134 Warren Ave.

Academy for Active Learners

RE: Response to Comments  
Level II Site Plan Application  
Academy for Active Learners  
134 Warren Avenue  
Portland, Maine

TYPICAL SIDEWALK/DRIVEWAY (NEW/REPLACEMENT)
NOT TO SCALE

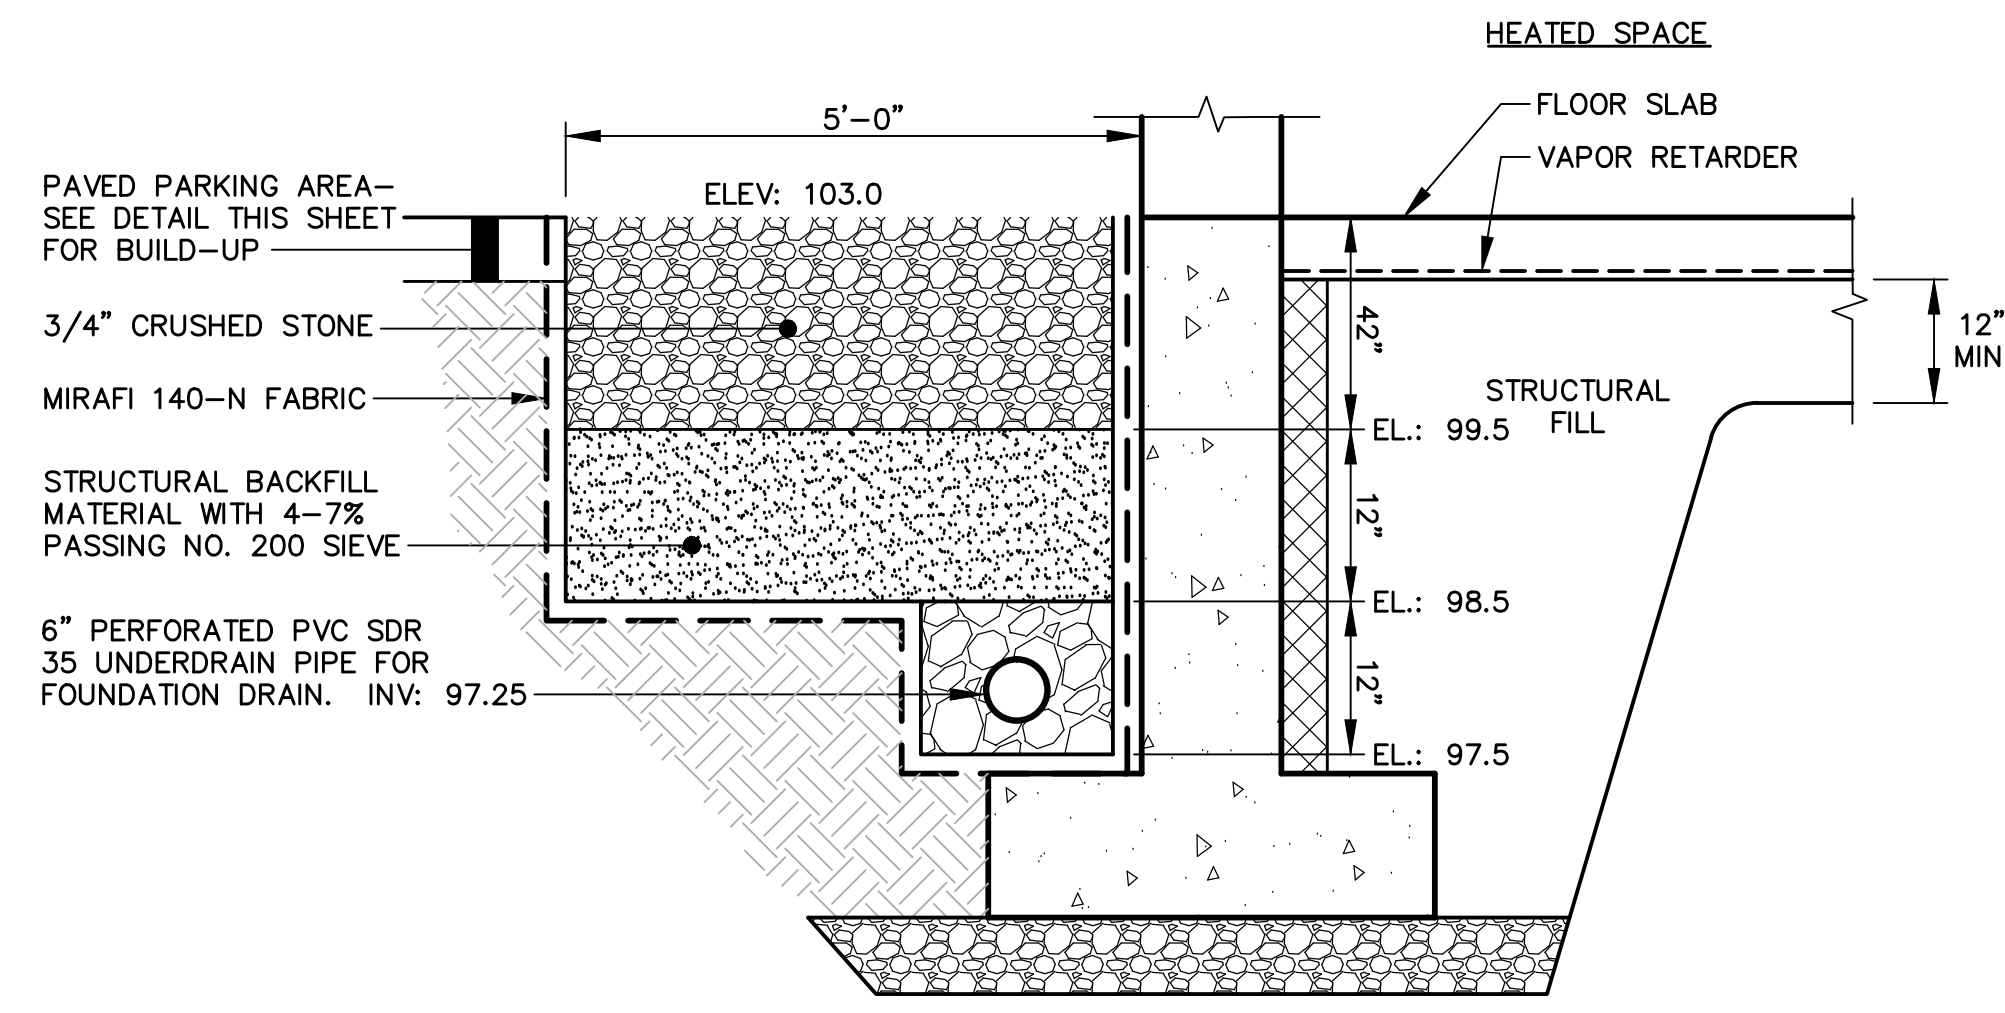
**b) Bituminous Sidewalk (Technical Manual detail I-12)**

Response: Sheet C-103 has been revised to reflect the changes.
